HPE CM: RE: Notice of Exhibition - Lindfield Learning Village SSD 8114 Phase 2 and 3 Response to Submissions

Based on a preliminary assessment of the documentation in support of proposed Phases 2 and 3 of the Lindfield Learning Village, additional information is required for further assessment:

**Figure 9 APZ and Radiant Heat Load on Buildings** (Grubits and Associates Bushfire Radiation Assessment Report)

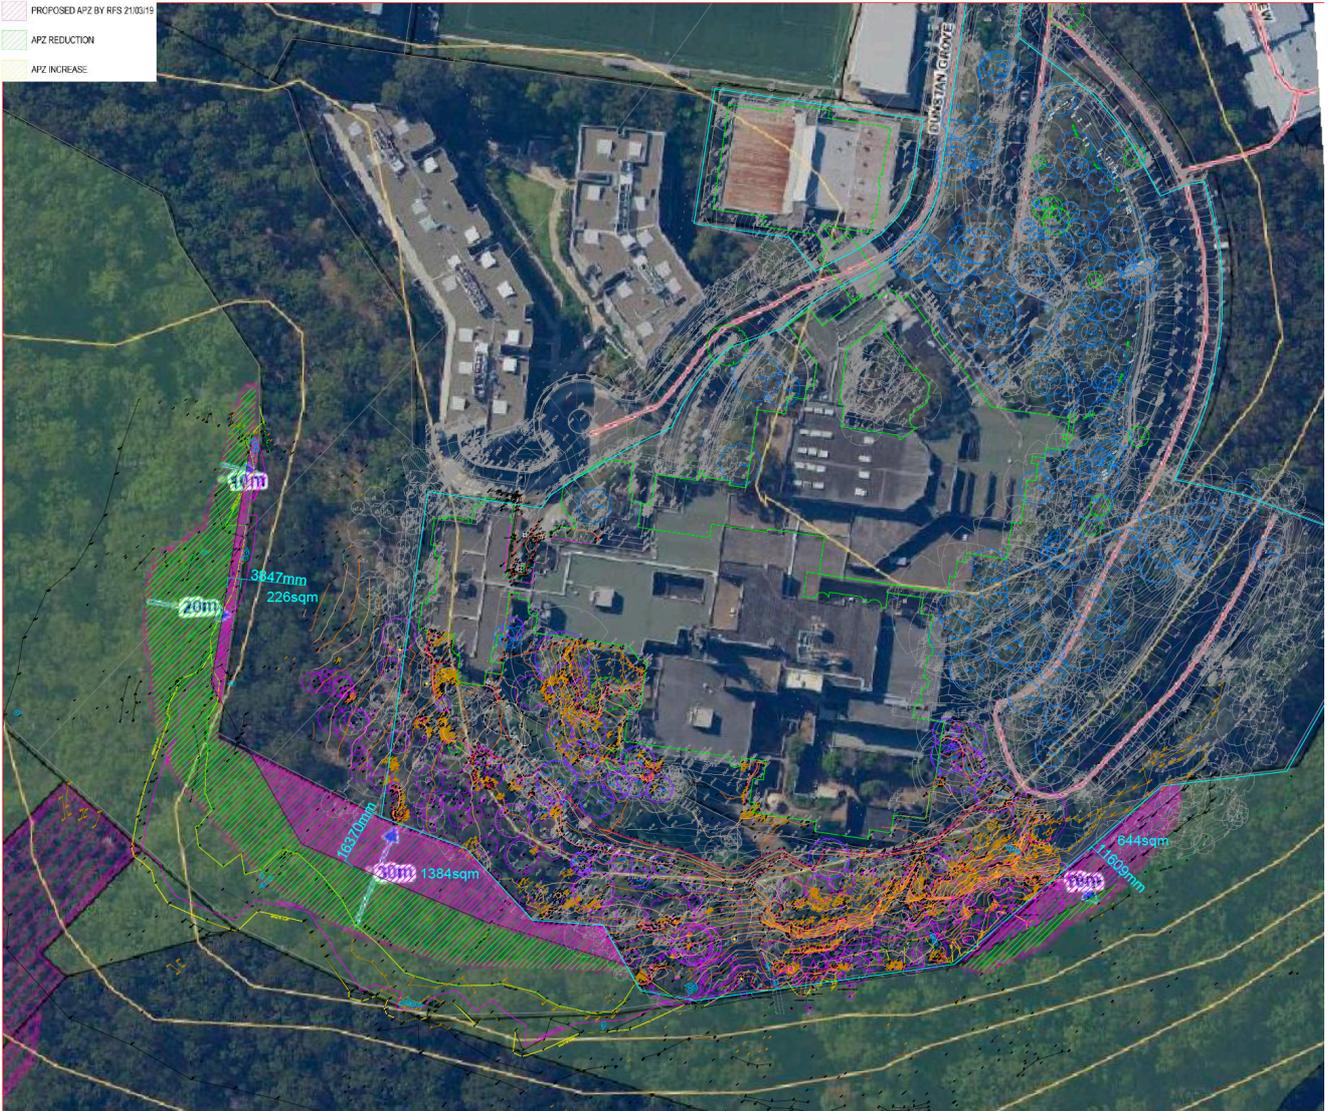
- Updated plan(s) denoting the proposed asset protection zones (APZs) off site and confirmation from National Parks and Defence Housing Australia regarding the ongoing management of the specified APZs need to be provided.

- The subject application does not include approval for the management of the APZs proposed off site.
 - These off site APZs have been relied on as part of the performance based solution in the 'Bushfire Radiation Assessment Report' prepared by Stephen Grubits and Associates (date: 22 August 2019, reference: 2018/321 R5.0) to demonstrate compliance of the existing structure with the provisions for special fire protection purpose (SFPP) development in *Planning for Bush Fire Protection 2006*.

- Details on the radiant heat modelling inputs and calculations in the 'Bushfire Radiation Assessment Report' prepared by Stephen Grubits and Associates (date: 22 August 2019, reference: 2018/321 R5.0) need to be provided

- Detailed radiant heat modelling calculations for Long Sections 1 to 11 are required similar to that provided in Appendix A of the report.
 - Any variations in input, including reduced flame temperature and dispensation in considering flame length, need to be justified.
